Application 6/2021/3172/FULL

I have received notification from you of a further application by the occupants of 51 Kentish Lane for a change of use of the property from a dwellinghouse to a mixed use as a dwellinghouse and a commercial film set.

Project:	51 Kentish Lane Brookmans Park AL9 6NG	Drawn By:	AEH
Drawing Title:	Site Plan Lighting Exclusion Zone	Date Drawn:	03/02/2021
Scale:	1:500 (A3)	Drawing Number:	TDC058/PL2/001
Rev:	-	Rev:	-

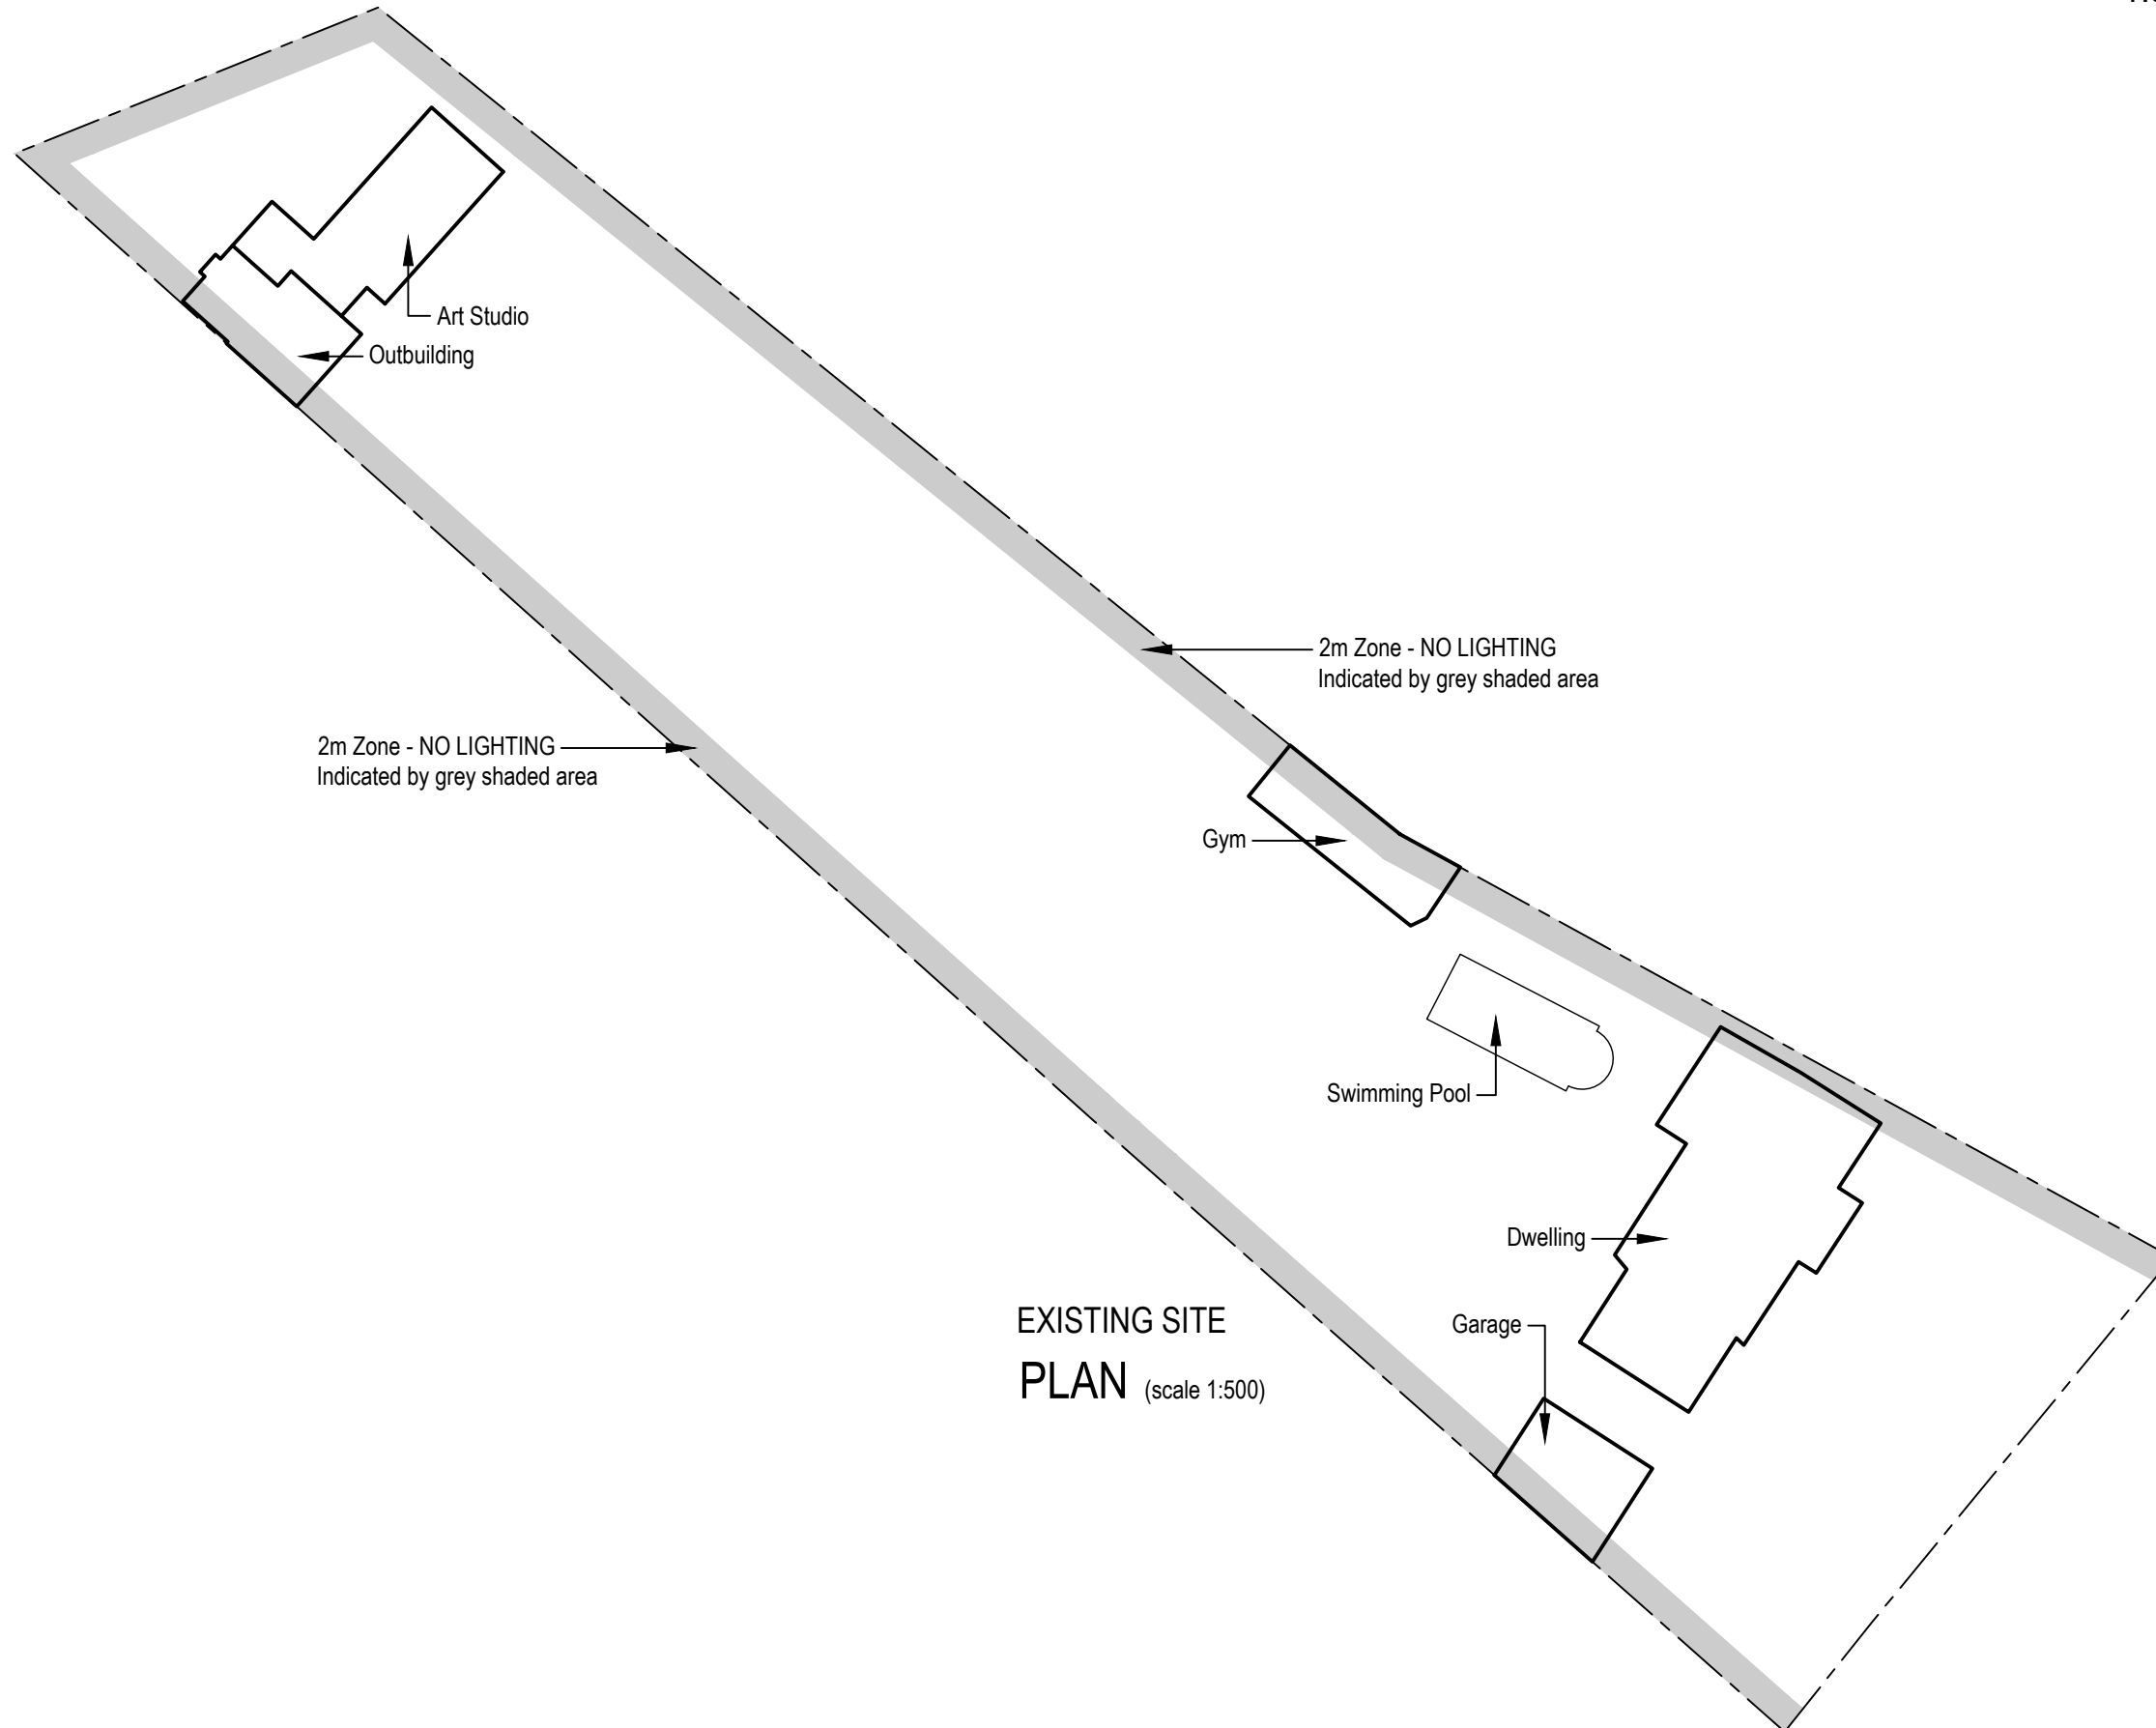
Paragraph 4.26 of the Planning Statement refers to limitation of lighting and measures taken to prevent light-spill and refers to the presence of dense conifer planting exceeding 10m in height on the boundary. While it is correct that the owners of No [REDACTED] have allowed dense conifers to grow on their boundary to a height of about 6 -10m and that this may mitigate visual intrusion, it is at the expense of permanent shading and effect on vegetation in the adjoining properties.

DRAWING TITLE  
**Potential Parking Space Arrangements**

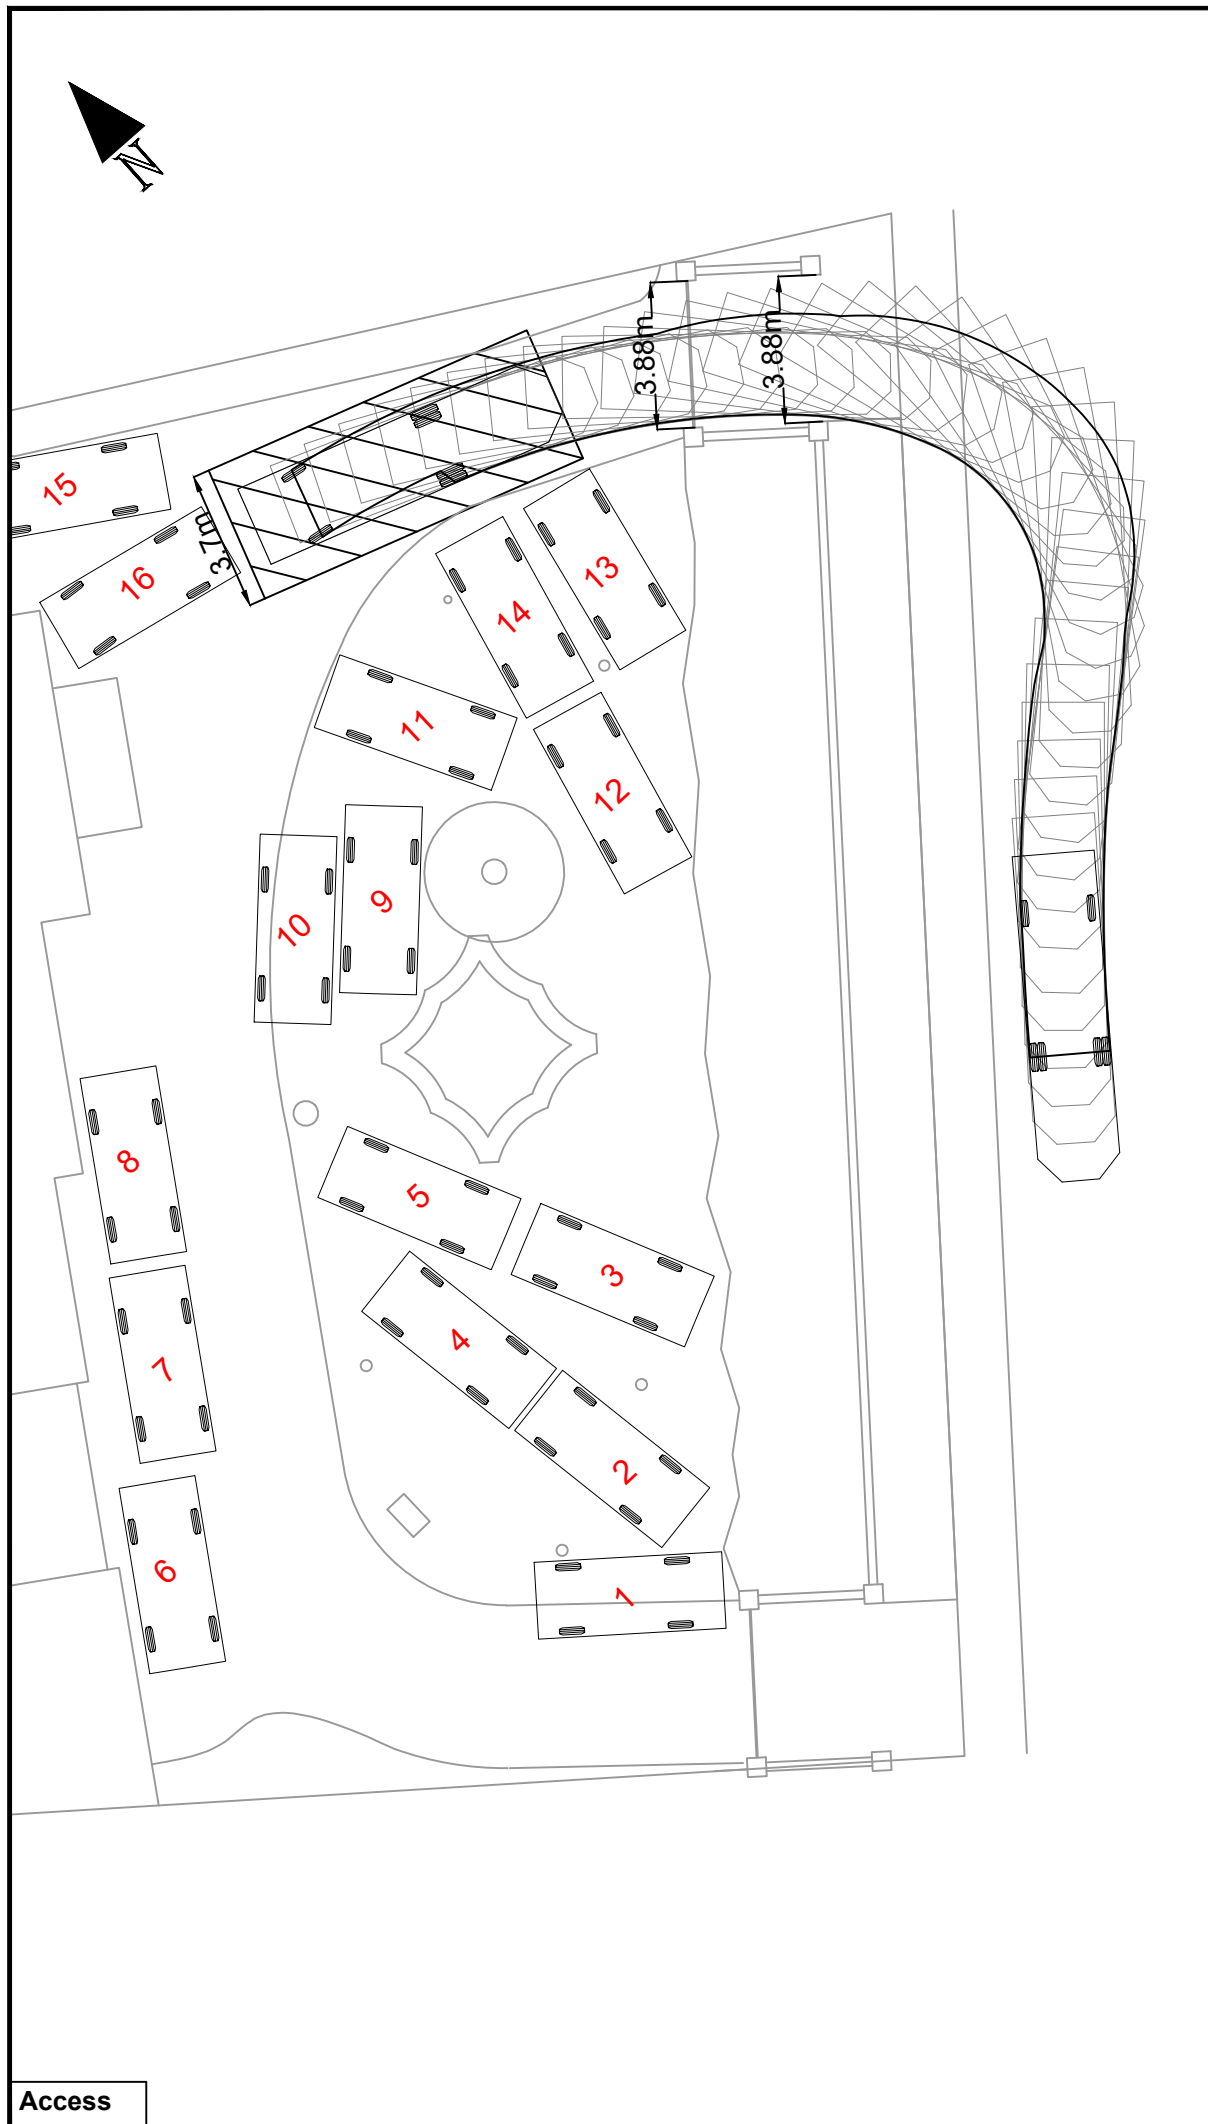
The Events Management Plan is stated to have been submitted to the Highway Authority, showing the intended parking provision in the front garden and limiting filming to the rear garden. The submitted parking plan is said to demonstrate how 20 cars can be parked with room left for a minibus or a van to enter and leave the site. This is an increase in the number of cars which the site was claimed to be able to accommodate in the previous application. I suggest that the applicant be required to physically demonstrate the viability of the parking arrangement and how it would be managed since on the face of the submitted drawing, no provision has been made e.g. for opening car doors. It is assumed that the gates to the property will be open during filming since there is no provision indicated for the inward opening gate swing.

- 2.3 Event recording: this should include the set-up and dismantling times in a similar manner to the actual filming times.
- 2.5 See previous comment regarding conflict with school traffic at 07:30 am
- 2.7 See previous comment, definition of an “activity period” is required
- 2.8-2.22 Viability of on-site parking to be demonstrated. The indication by the Highway Authority in the Pre Application letter that the parking appears viable refers to a different drawing and different number of parked vehicles.
- 2.24 To clarify if the 45m limit for fire brigade access referred to in the context of a house is also intended to apply to a film set in the rear garden in which case is there a limit on the extent of rear garden deemed safe for filming.
